From: Zac Denton
Sent: 22 July 2019 08:35
To: Planning.Responses
Subject: FW: EP 74/19/HH 2 Hillview Crescent East Preston

Proposed Elevations

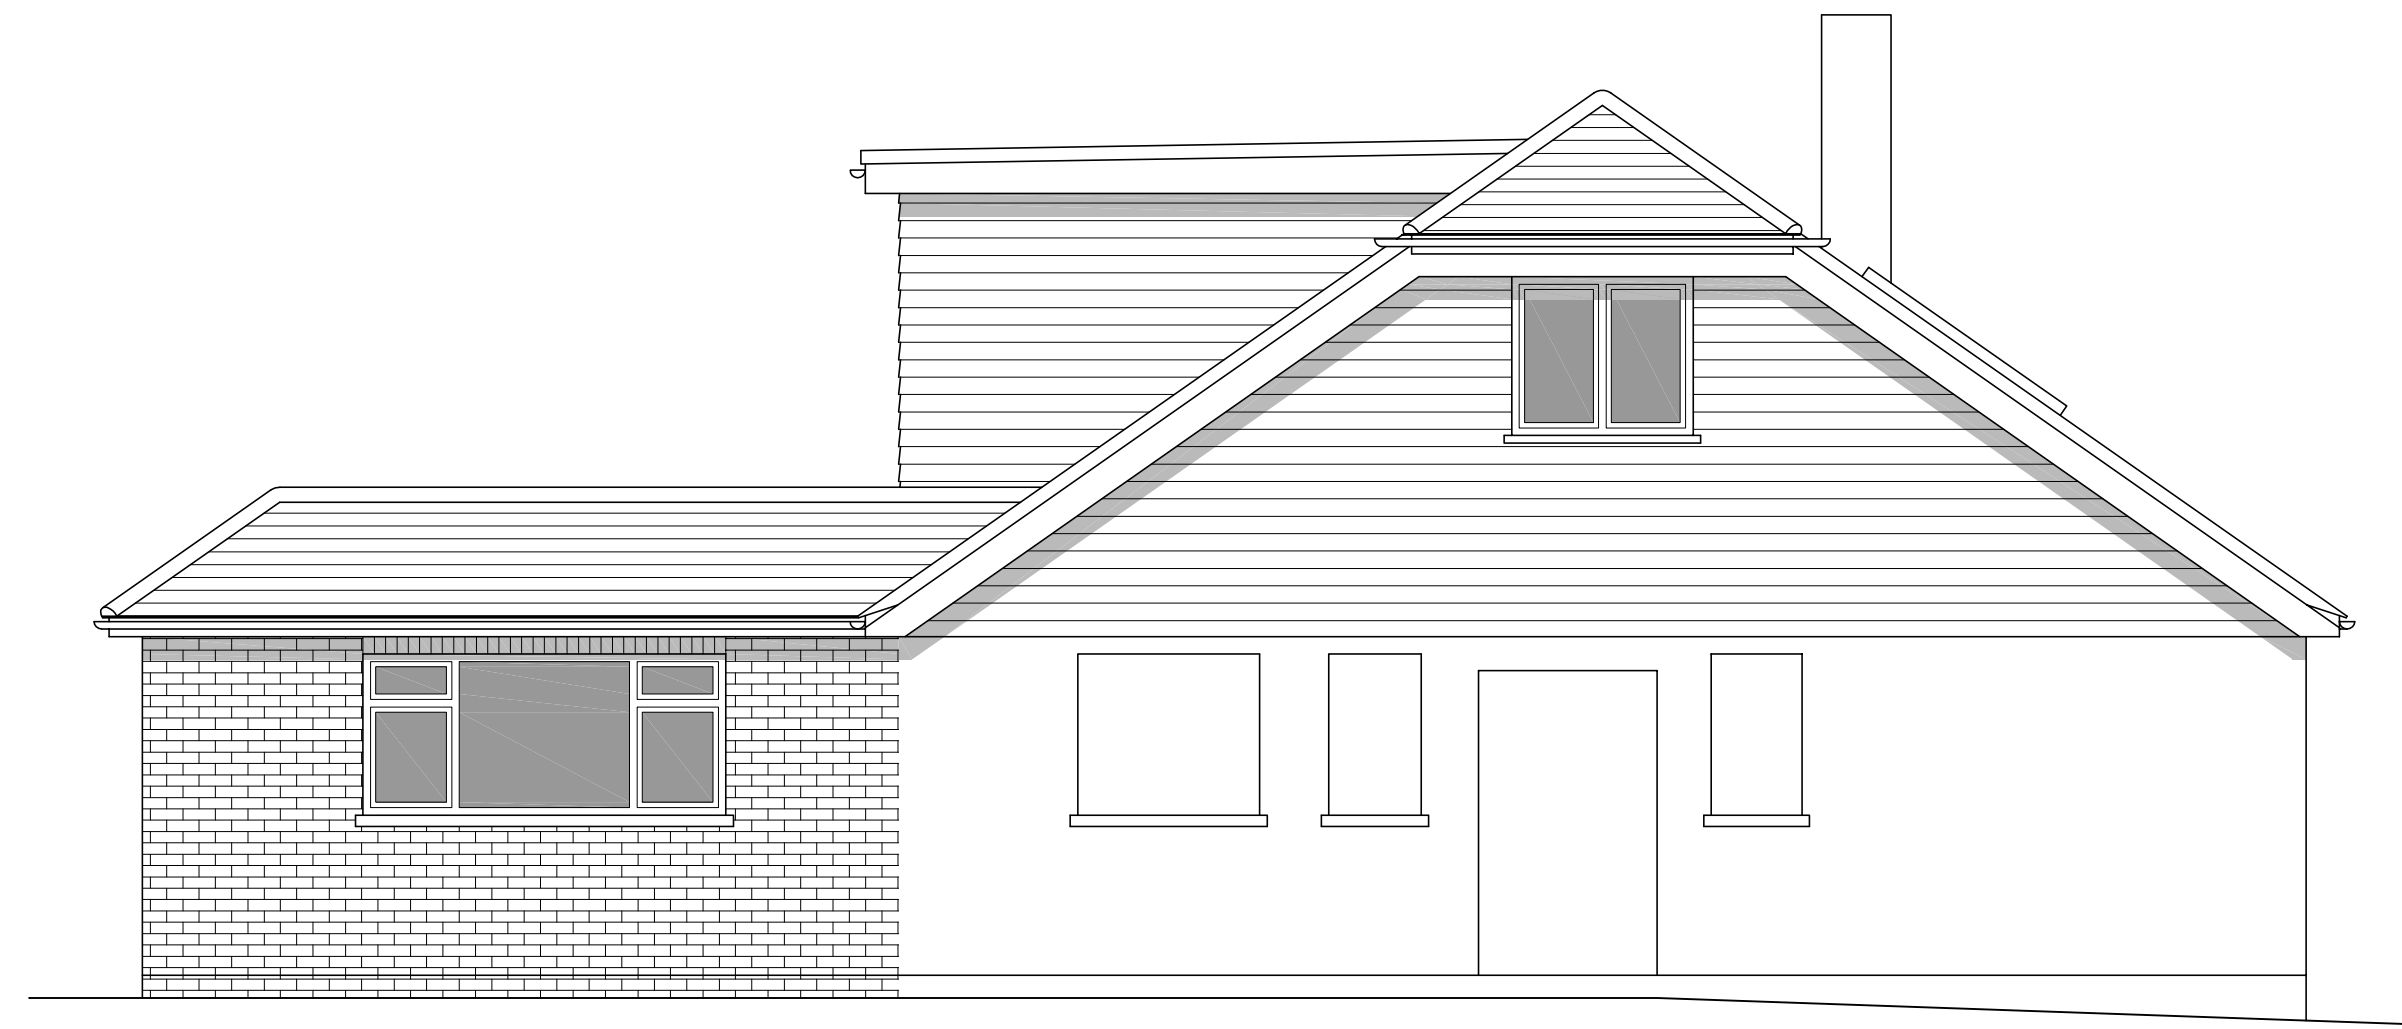
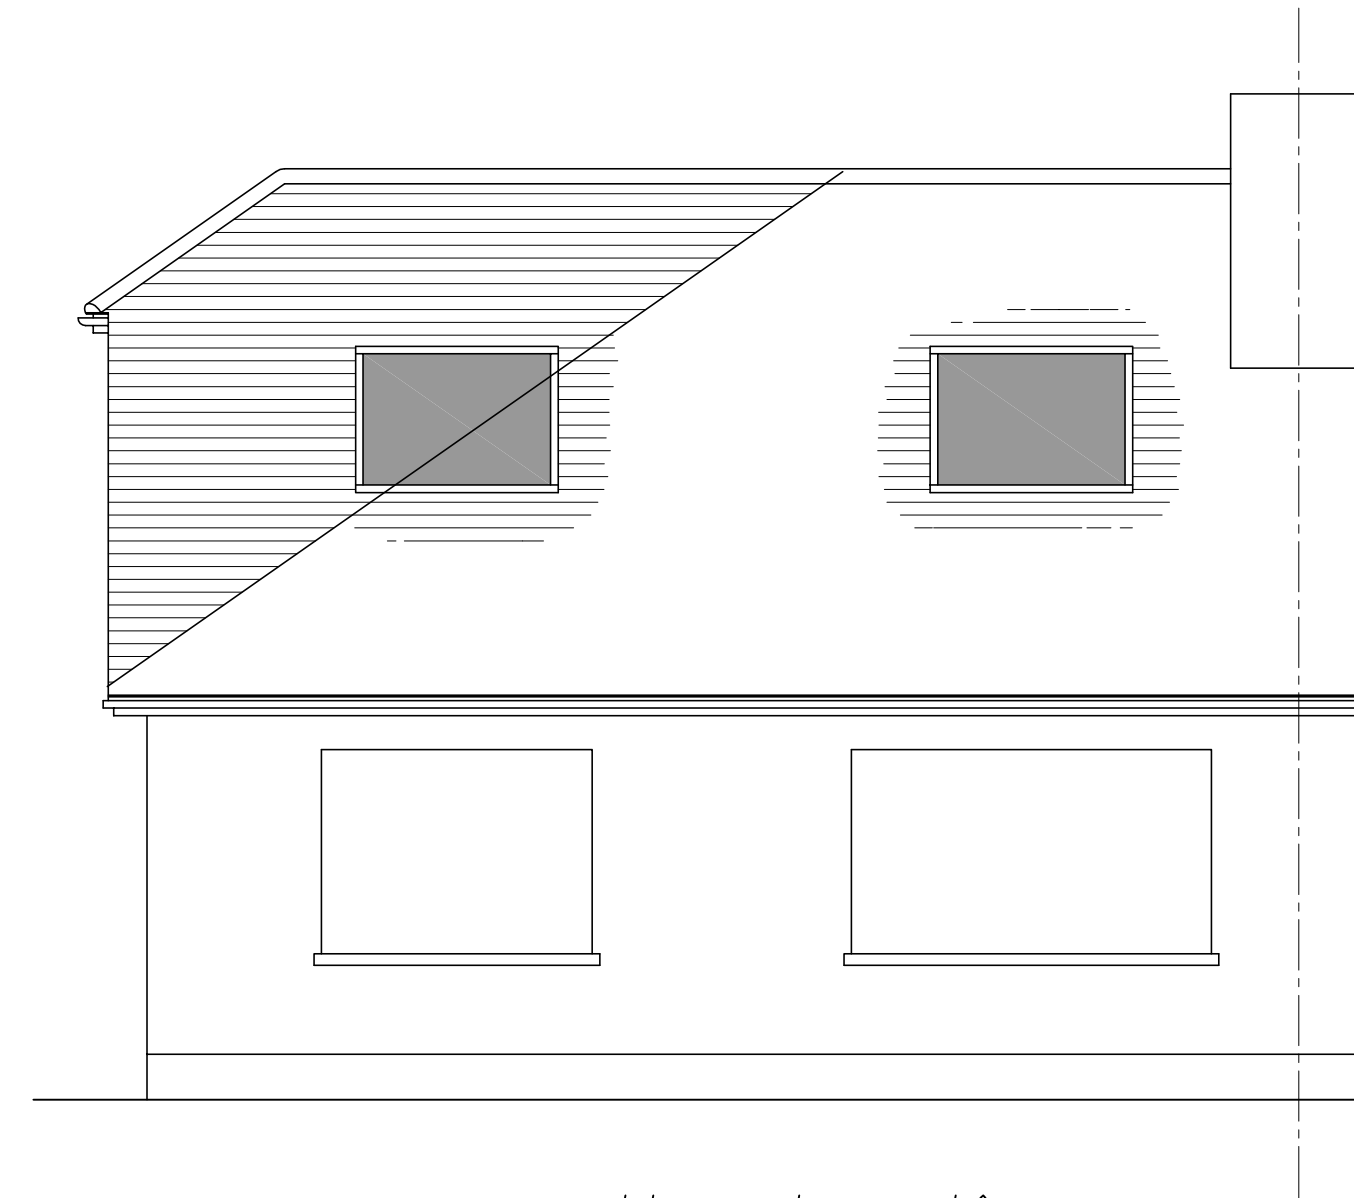
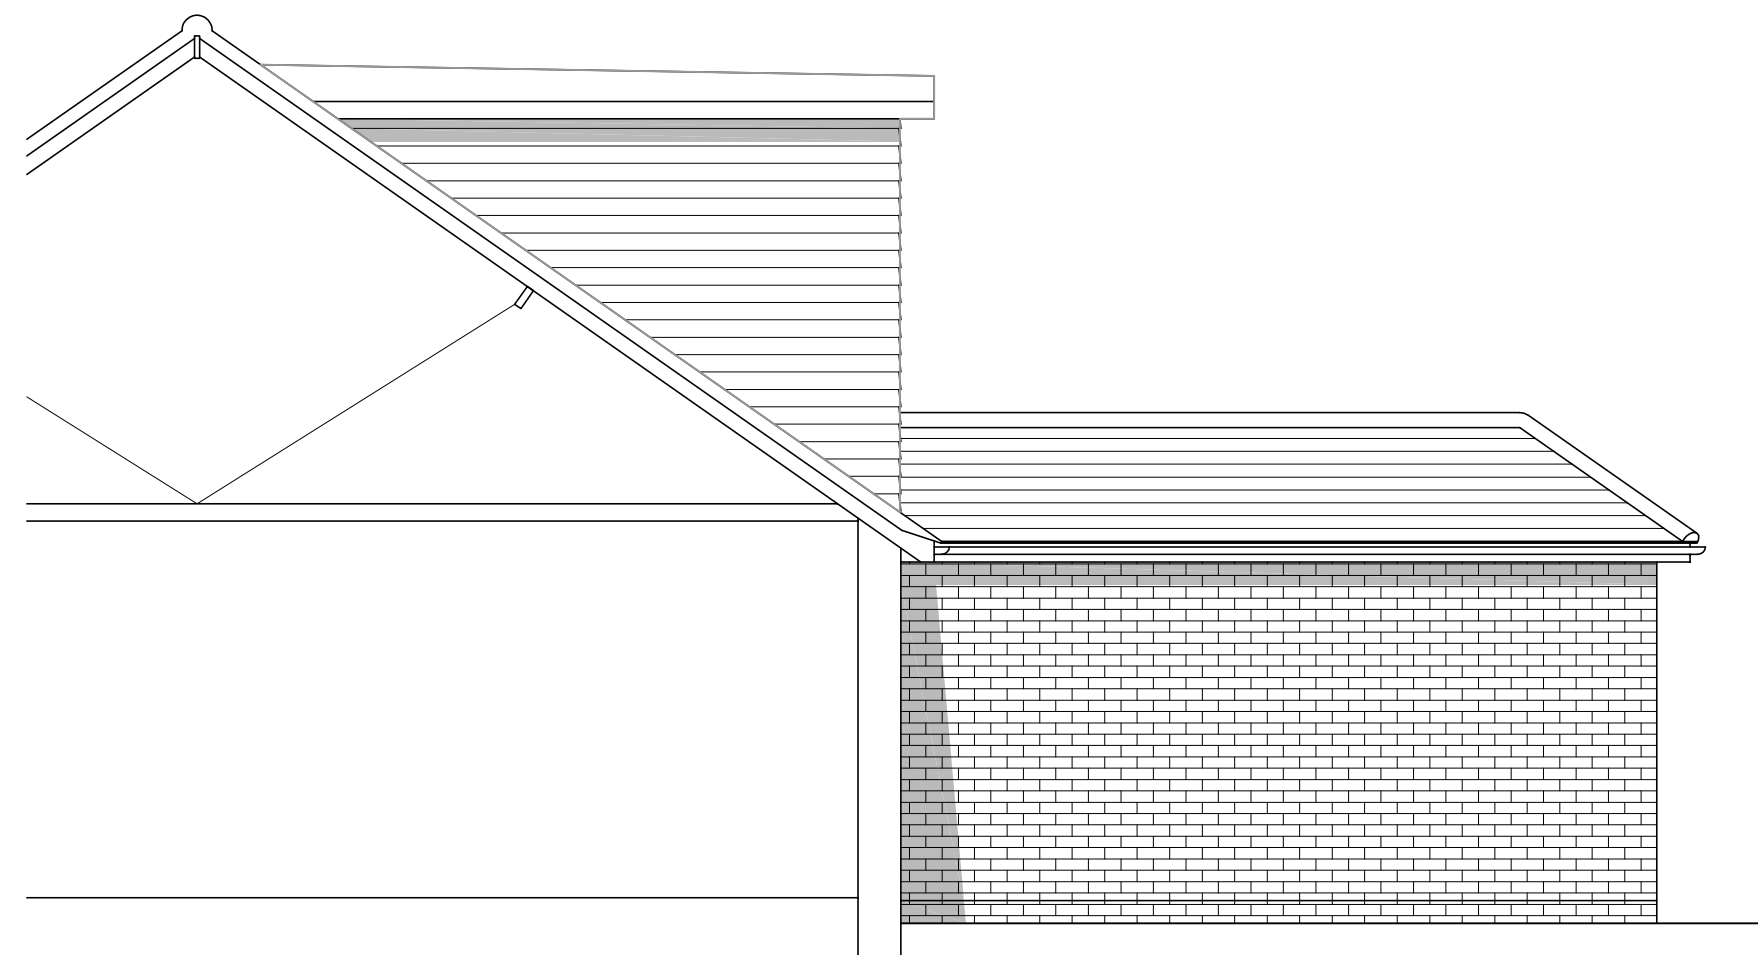
4/ Three properties will all still be detrimentally effected by being overlooked by the huge proposed dormer in the north elevation, taking away our rights to be able to enjoy our gardens, conservatories etc, for which was the main attraction for all of us of buying a bungalow in the first place. The effect on 2 Chiltern is quite dramatic as they will be directly overlooked straight in to there lounge/kitchen. There must be legislation/laws rules about proximity that can protect other householders from this sort of thing?

5/ It would appear that the detrimental effect that these plans would have on the street scene have again been ignored and will be totally out of character due to being in such a prominent corner position. Why?
